**Your Ref: 2025/92541**

**Our Ref: A/03159**

**27th March 2026**

**Land off Roslyn Avenue, Netherton, Huddersfield - (KIRK) Operational development to create development plateau comprising land level changes, highways construction, utilities diversions and drainage construction**

drawing title:
Proposed Drainage Scheme Plan

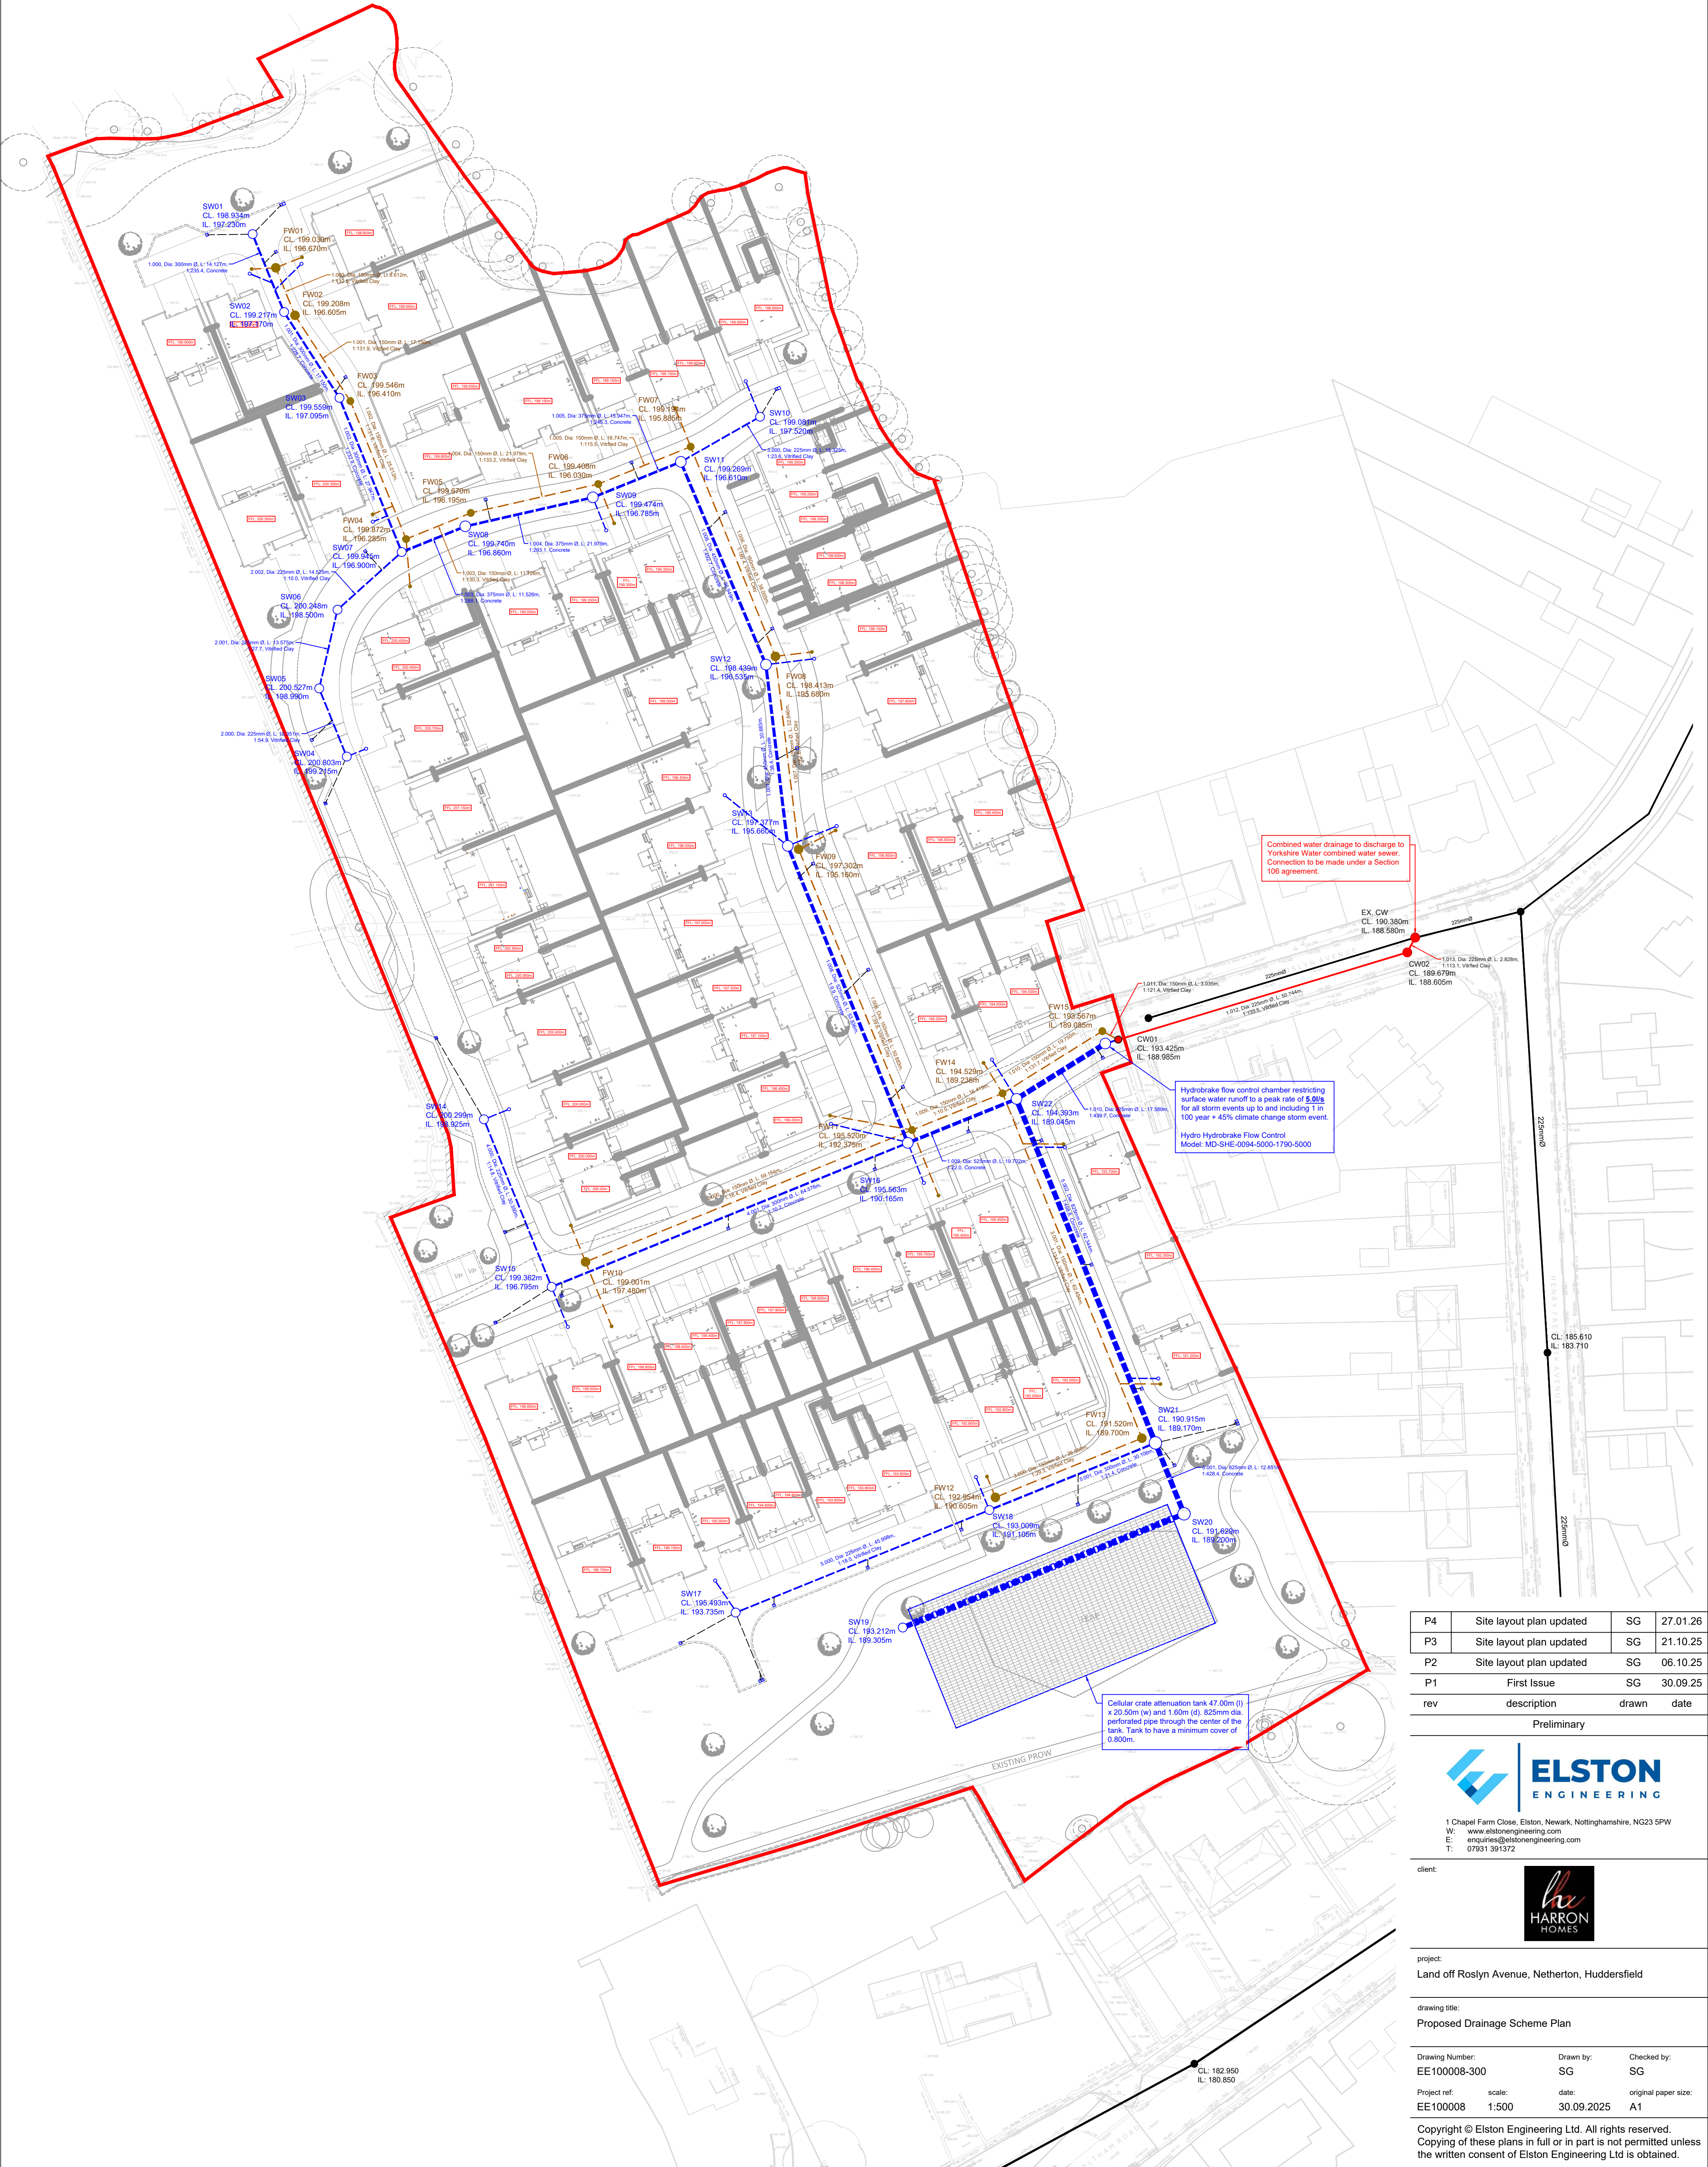
**The development shall be carried out in accordance with the details shown on the submitted plan, EE100008-300 (revision P4) dated 27/01/2026 that has been prepared by Elston Engineering, unless otherwise agreed in writing with the Local Planning Authority. (In the interest of satisfactory and sustainable drainage)**

- 1) The proposed separate systems of drainage on site with combined off-site
- 2) The proposed amount of domestic foul water to be discharged to the public combined sewer network
- 3) The proposed amount of curtilage surface water to be discharged to the public combined sewer network at a restricted rate of 5 (five) litres/second
- 4) The proposed point of discharge of foul and surface water to the 225 mm diameter public combined sewer in Roslyn Avenue

submitted on drawing EE100008-300 (revision P4) dated 27/01/2026 that has been prepared by Elston Engineering.
